# A12 Chelmsford to A120 widening scheme

## 8.19 Statement of Common Ground with Hatfield Peverel Parish Council

**Statement of Common Ground with Hatfield Peverel Parish Council**

FIGURE 12.4

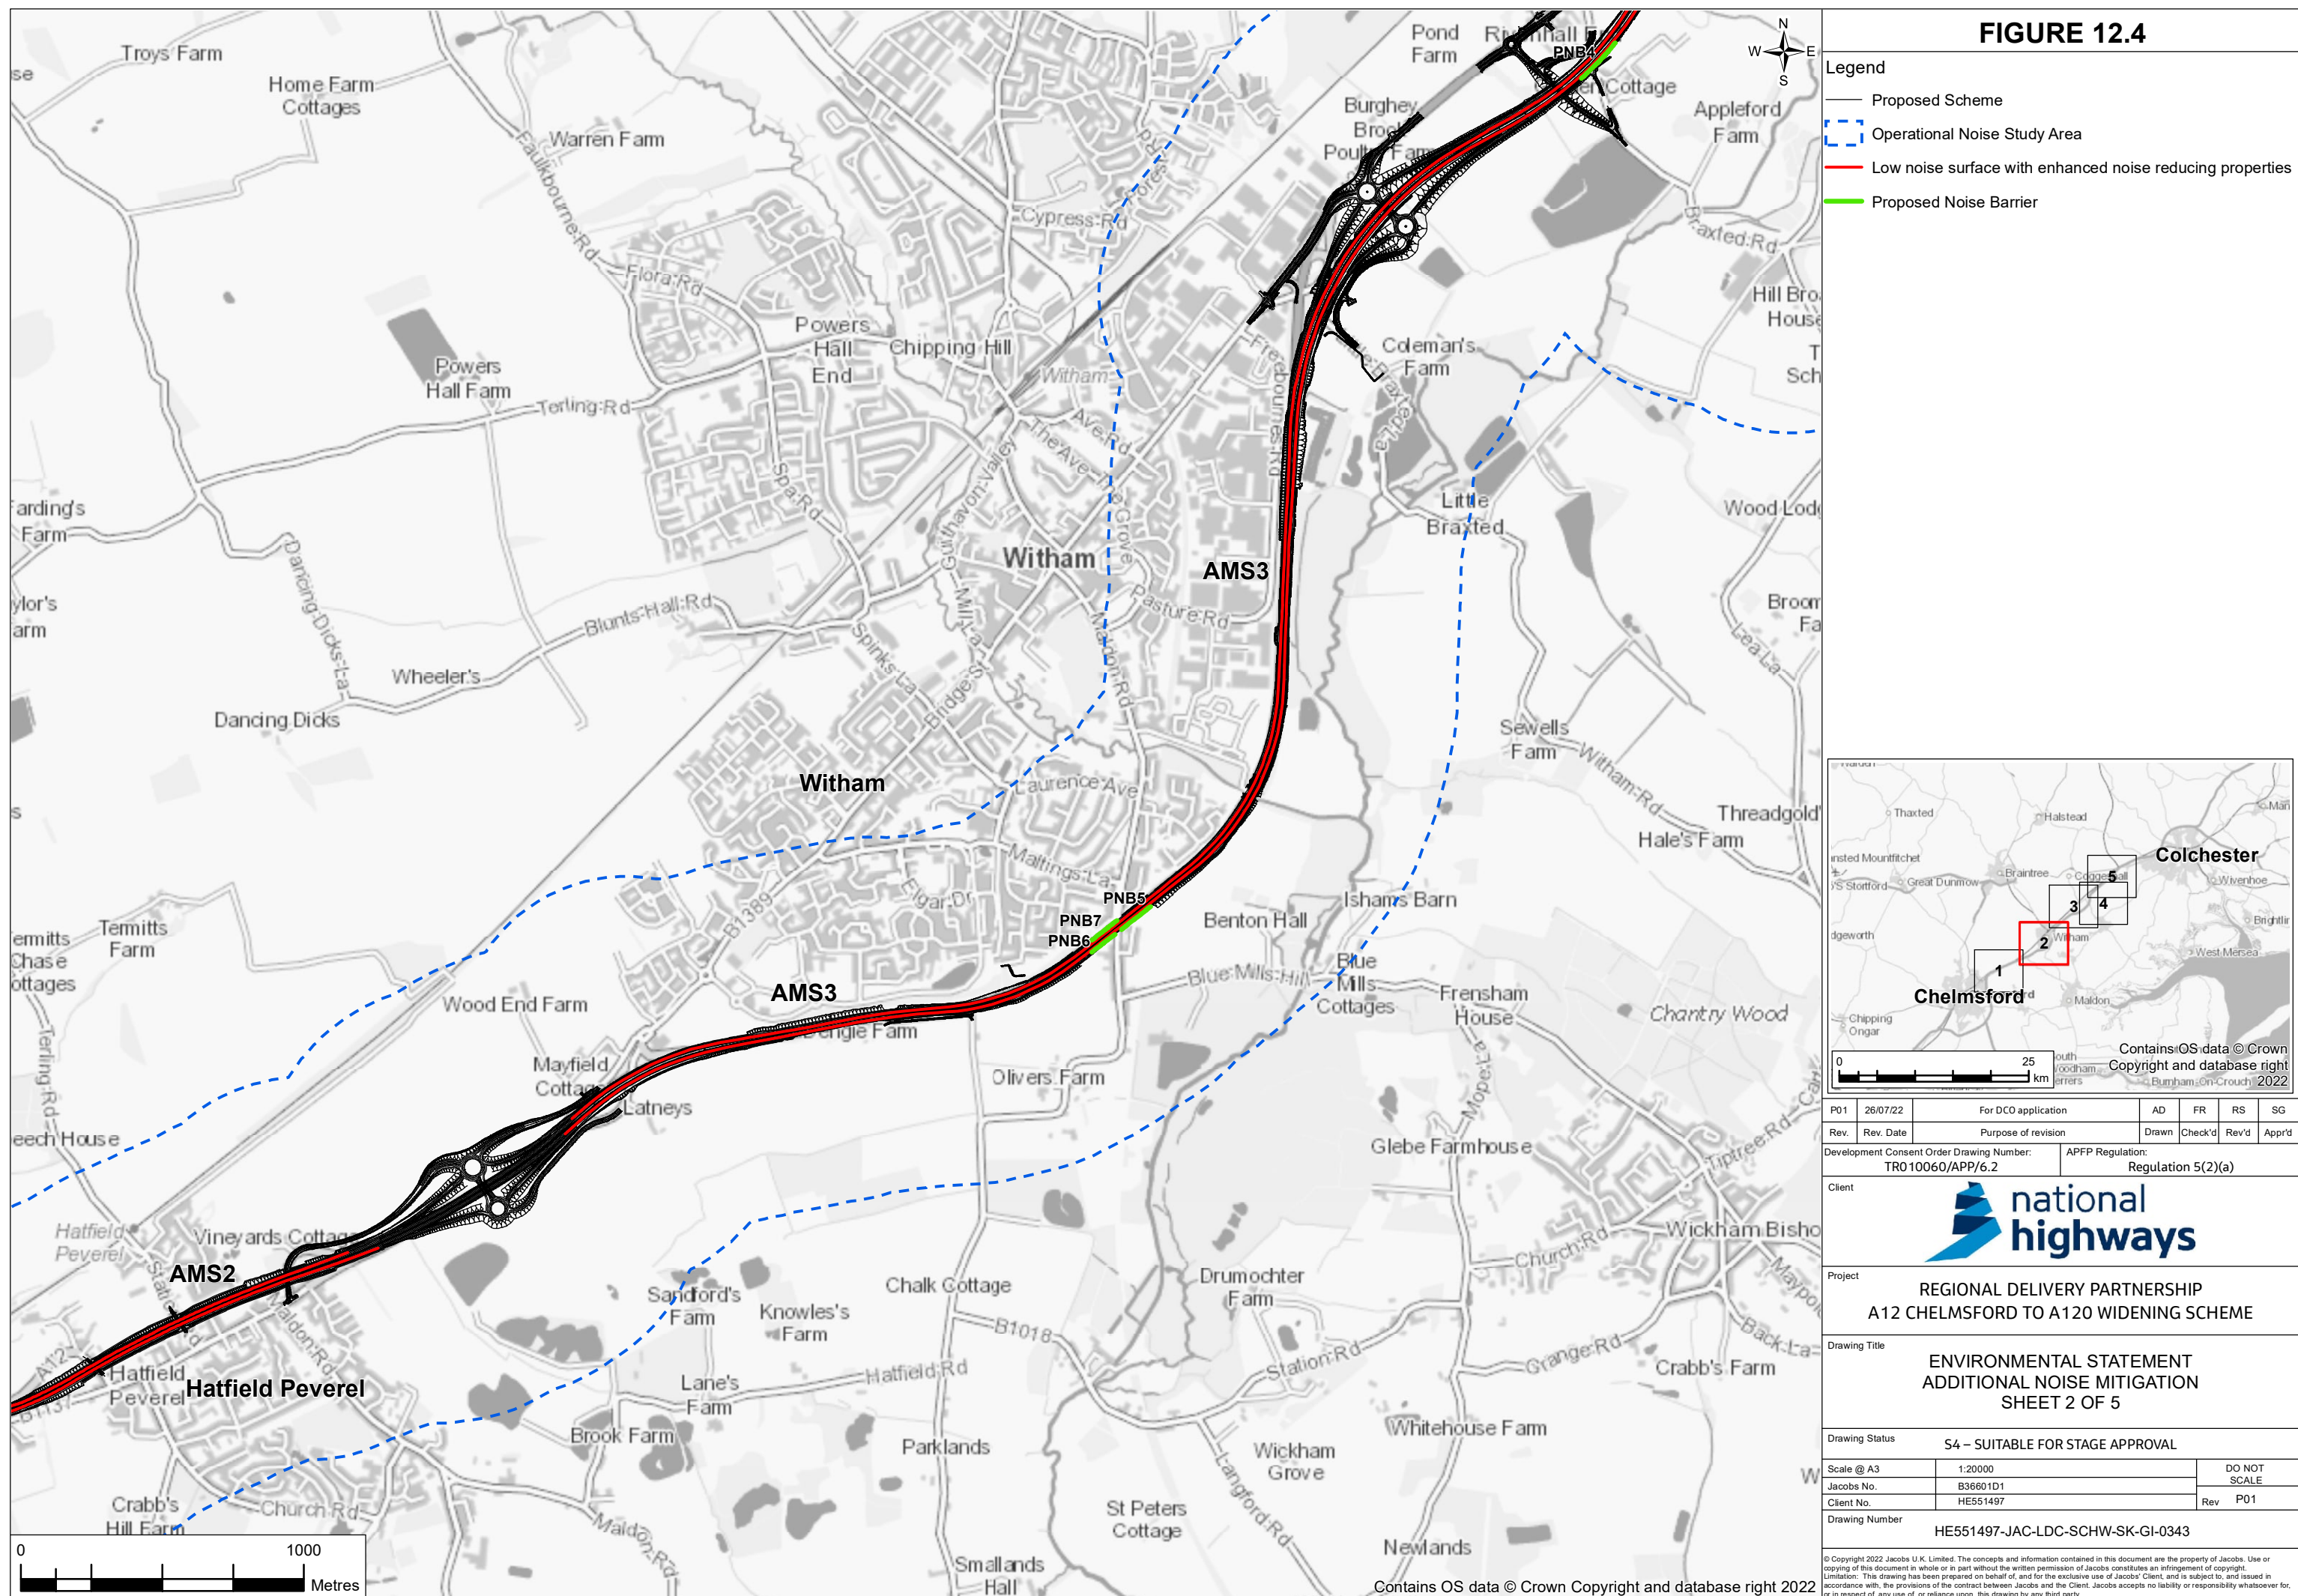
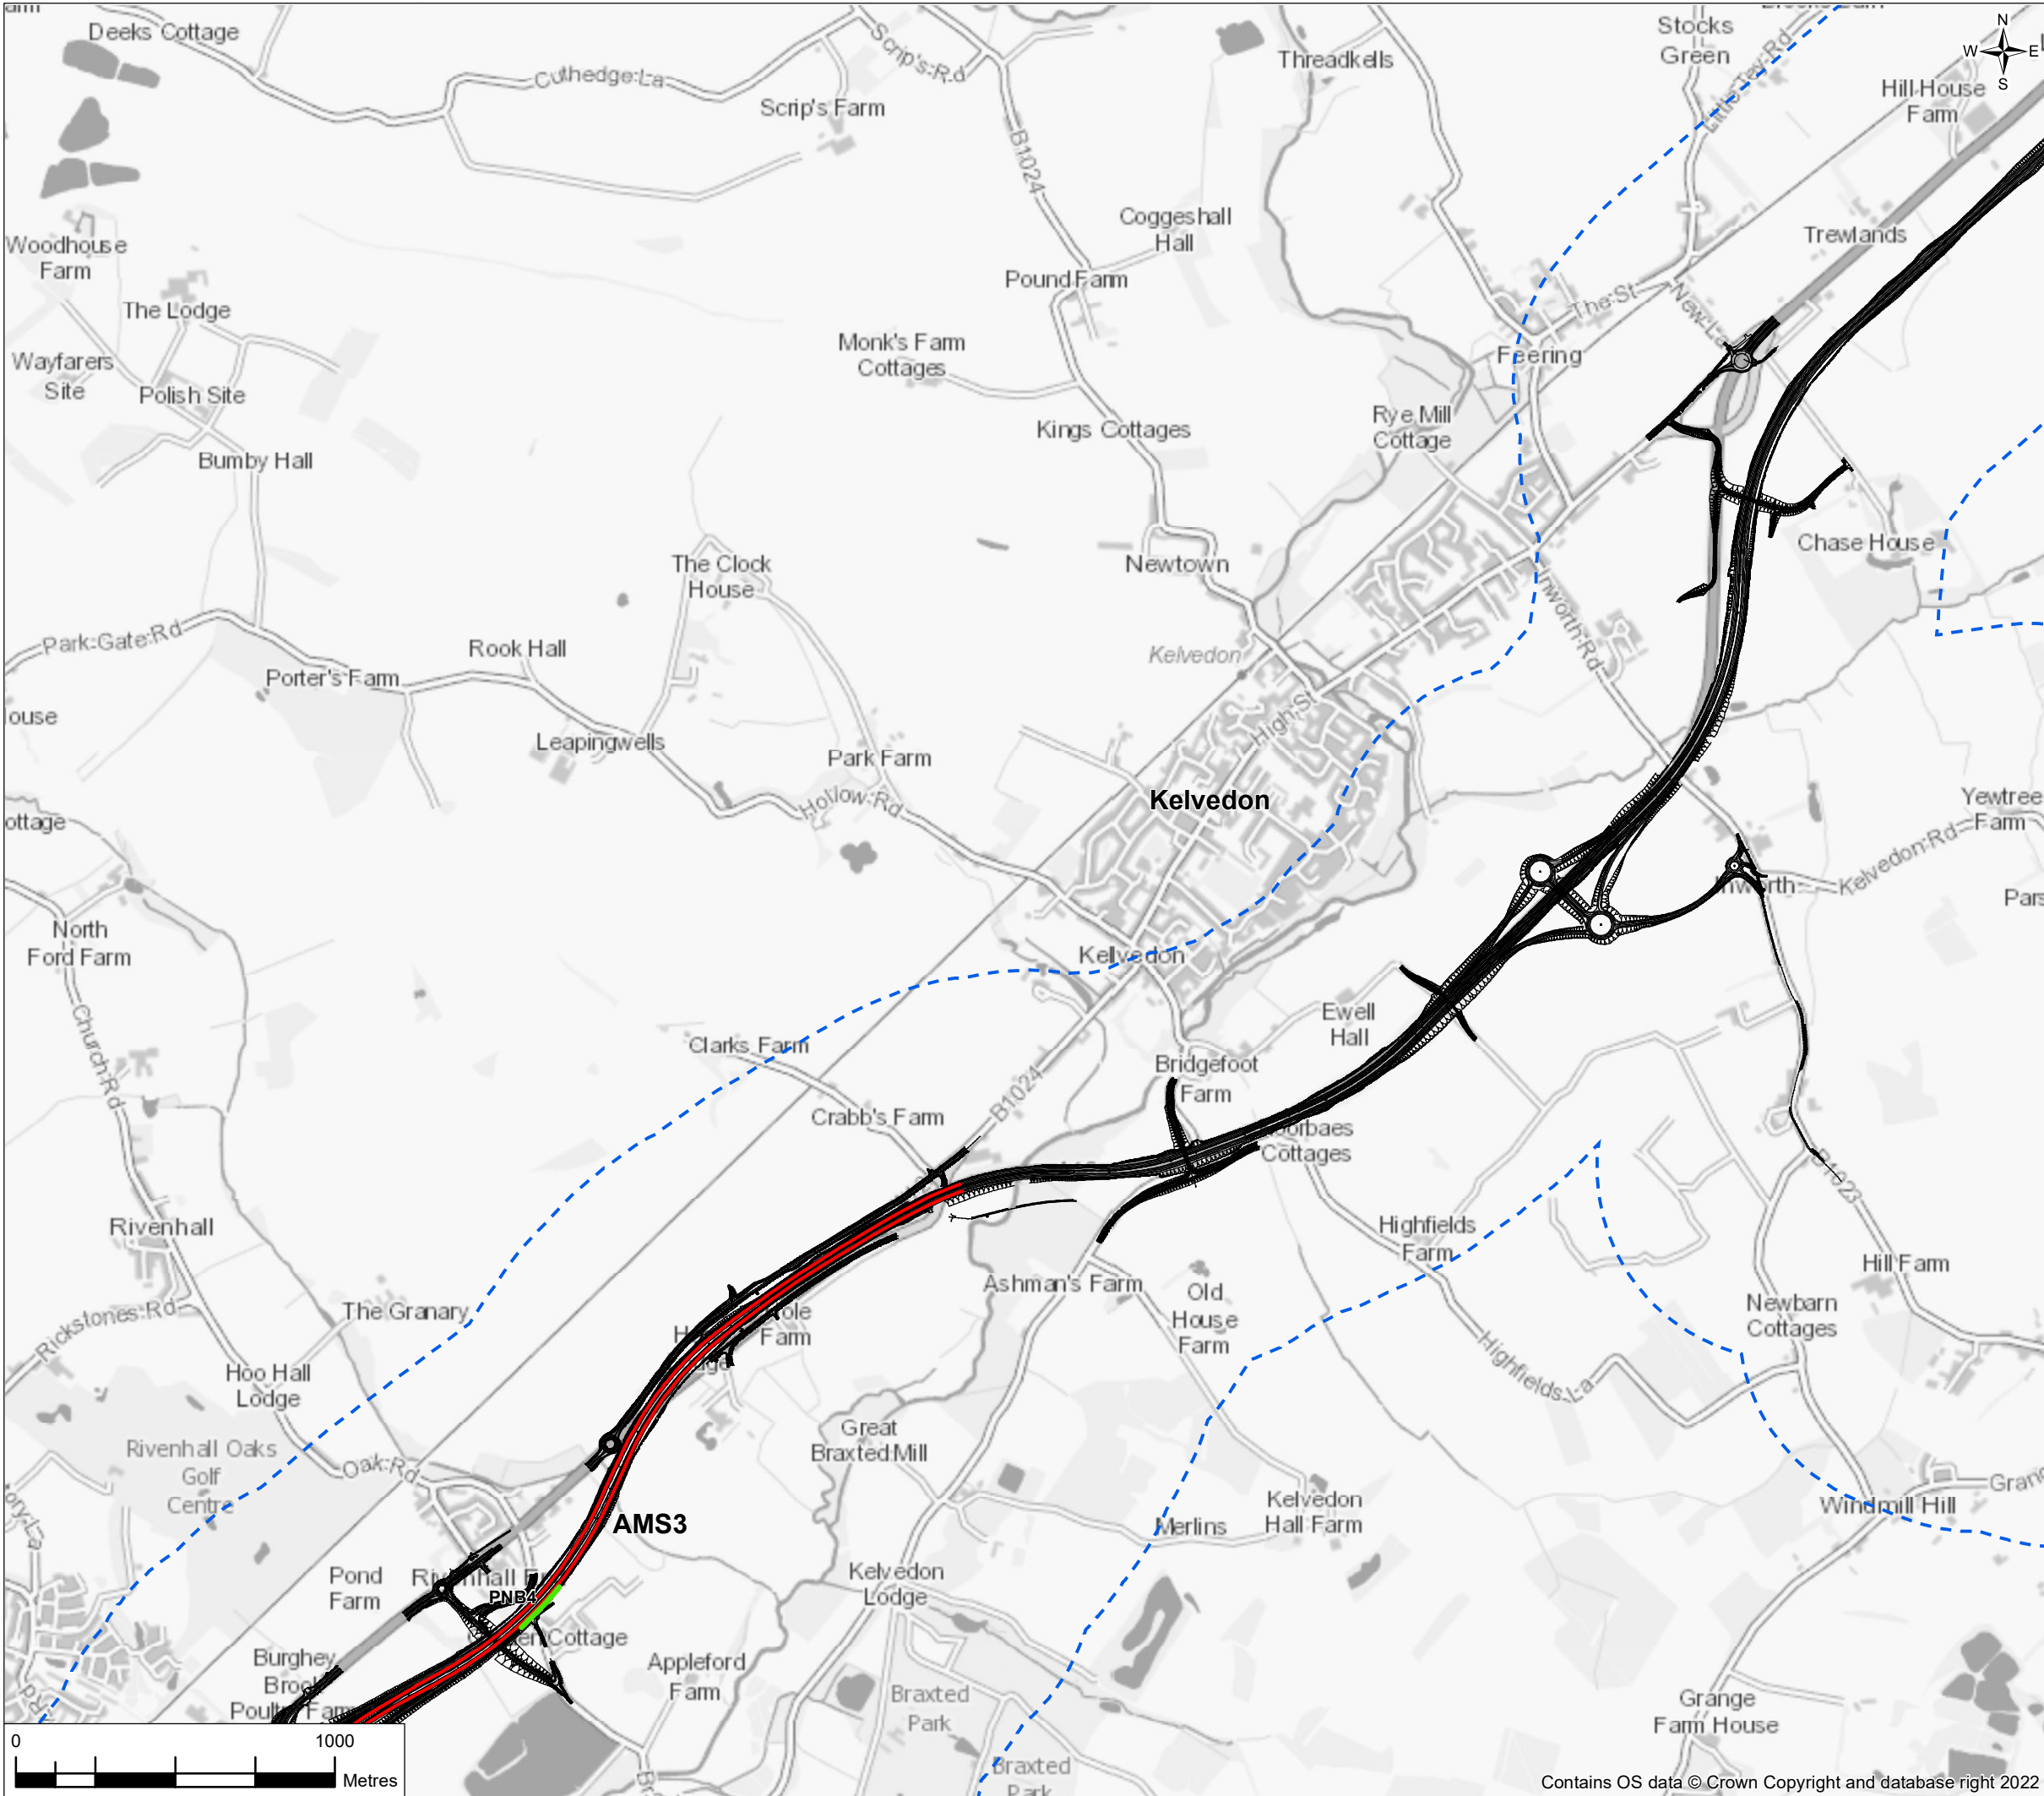
| Ref | Issue | Doc Reference  | Hatfield Peverel Parish Council   | National Highways Position   | Status  | Date       |
|-----|-------|--|---|--|---------|------------|
| 1.2 | Noise | Environmental Statement - Chapter 12: Noise and Vibration [APP-079]<br><br>Figure 12.4 Additional Noise Mitigation Sheet 1 of 5 [APP-231]. | HPPC remains concerned about the potential lack of reduction in road noise through the cutting between Bury Lane Bridge and Wellington Bridge. The reasons for not proceeding with the original proposal for noise barriers is understood but we have not yet seen a commitment to use road surfacing material which will take road noise down to at least minus 6.5db over standard surfacing. Residents of properties as far back as 200 metres from the existing highway have suffered ever increasing traffic noise for at least the past 35 years and it is essential that the maximum reduction in road surface noise | There is a commitment to use road surface with better noise reducing properties than a conventional surface (i.e. that with the RSI of minus 6.5 dB(A)) and it is contained within paragraph 12.10.17 of Environmental Statement - Chapter 12: Noise and Vibration [APP-079]. The section relevant to Hatfield Peverel is labelled AMS2 and is shown on Figure 12.4 Additional Noise Mitigation Sheet 1 of 5 [APP-231]. By reducing the noise at source, properties 200m back from the A12 would benefit from a noticeable | Agreed. | 27/03/2023 |

| Ref | Issue                                | Doc Reference | Hatfield Peverel Parish Council  | National Highways Position  | Status  | Date       |
|-----|--------------------------------------|---------------|--|---|---------|------------|
|     |                                      |               | be achieved in order to restore some quality of life for these residents.  | reduction in noise that would not be achieved if noise barriers were used.  |         |            |
